Addendum 04

Date: September 28, 2011

To: Wright Ryan Construction (Construction Manager)
From: Ben Walter, CWS Architects
Regarding: **Elm Terrace** – Portland, Maine
Subject: **Addendum 04**

Modify the previously issued documents dated September 8, 2011 and any previously issued addenda, if applicable, as follows:

**2** PERIMETER SOFFIT DETAIL  
 REFERENCED FROM: SCALE: 3"=1'-0"

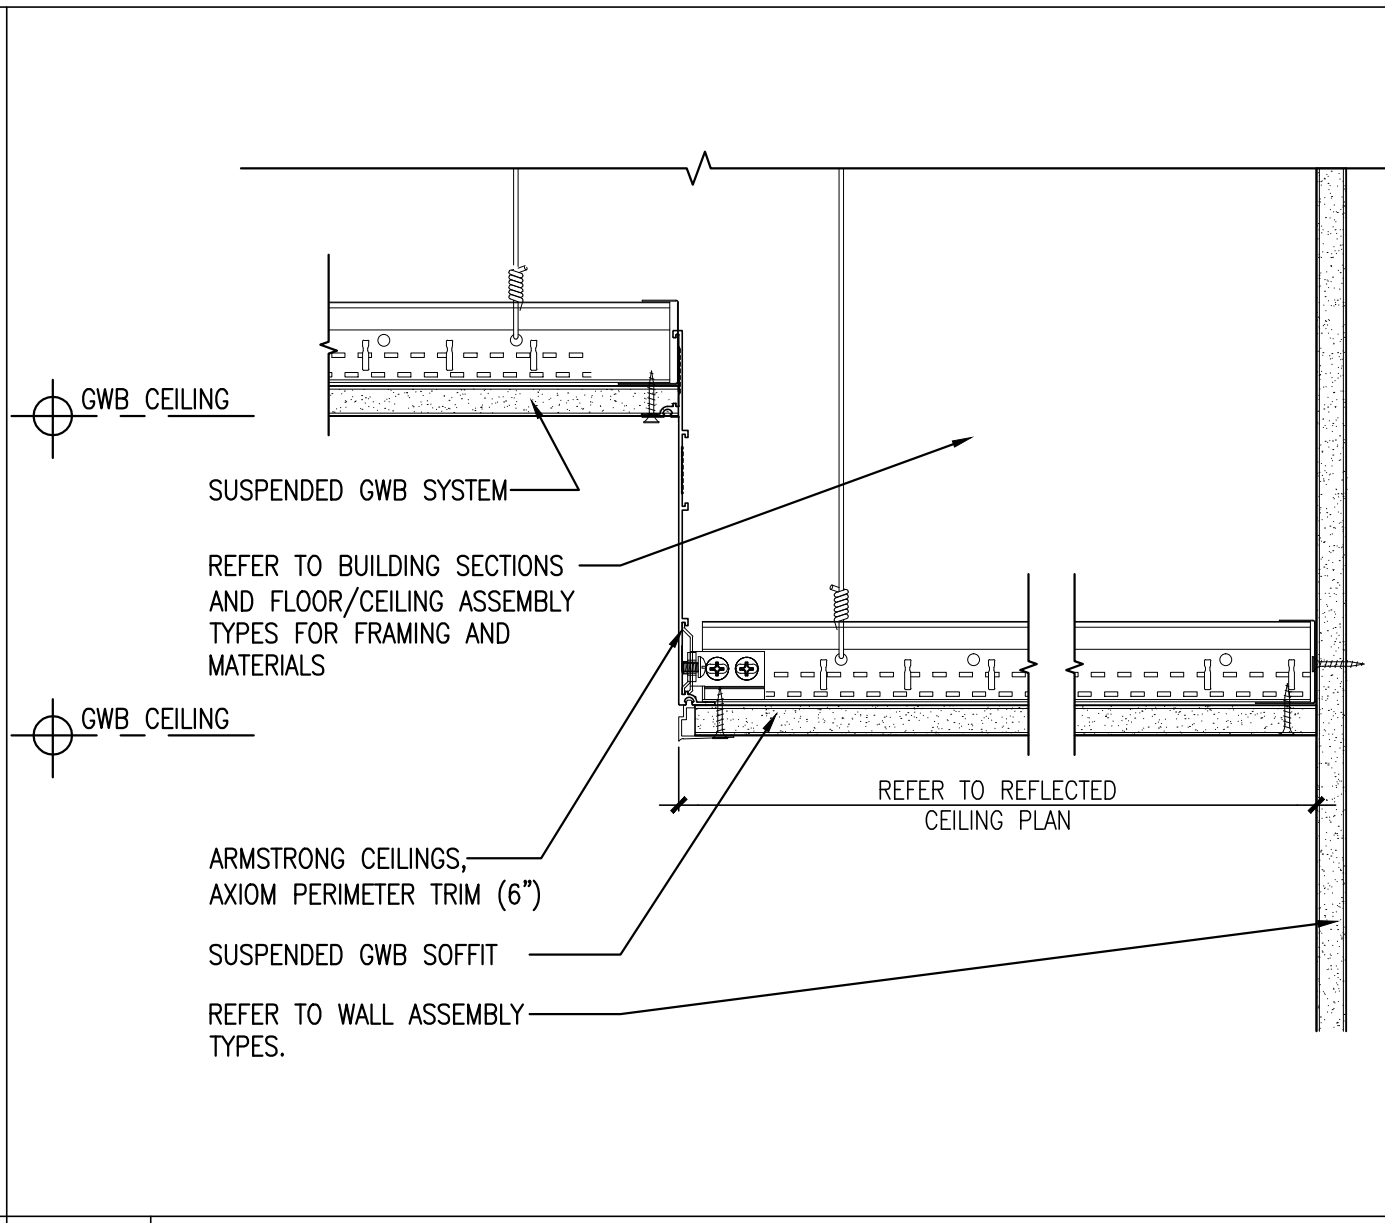
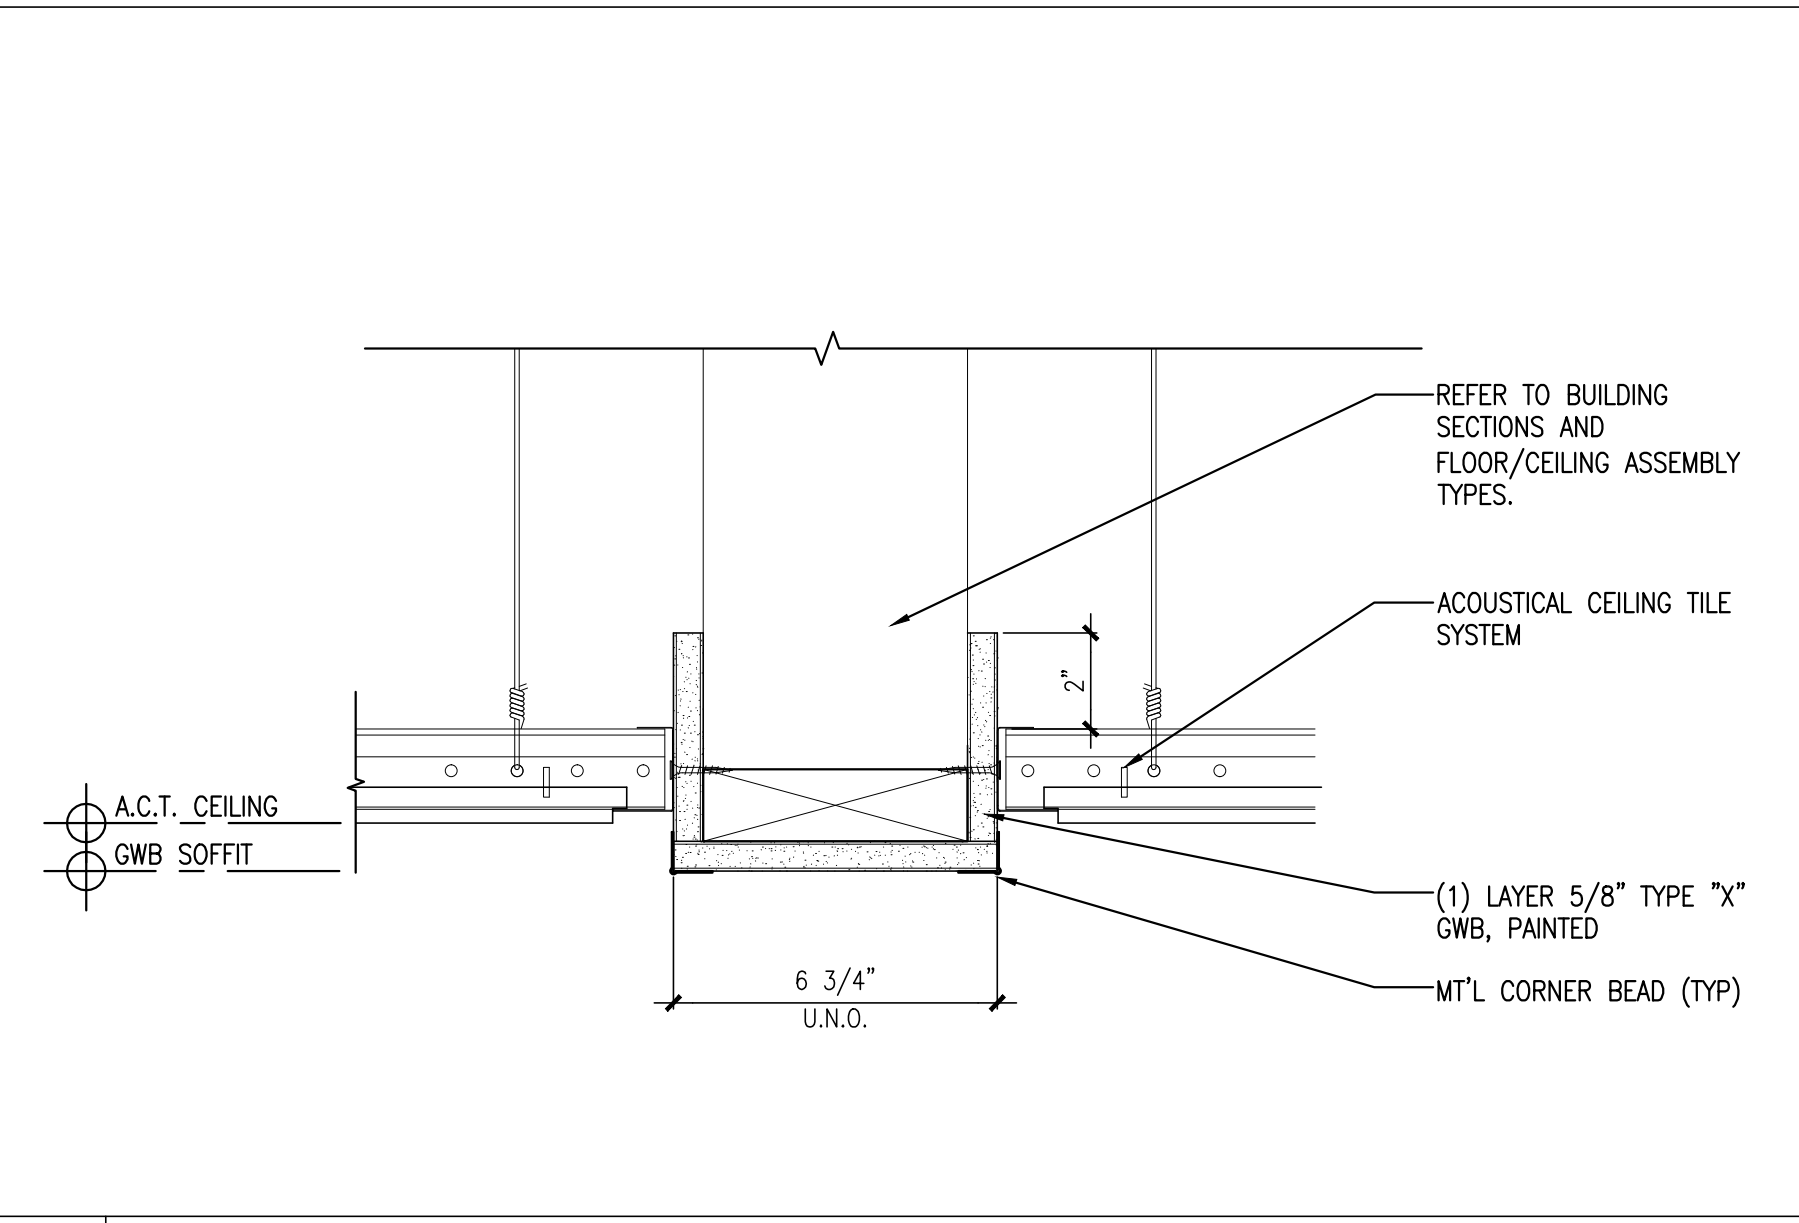
5. Delete Detail 2 on Drawing A2.10. The detail does not apply.
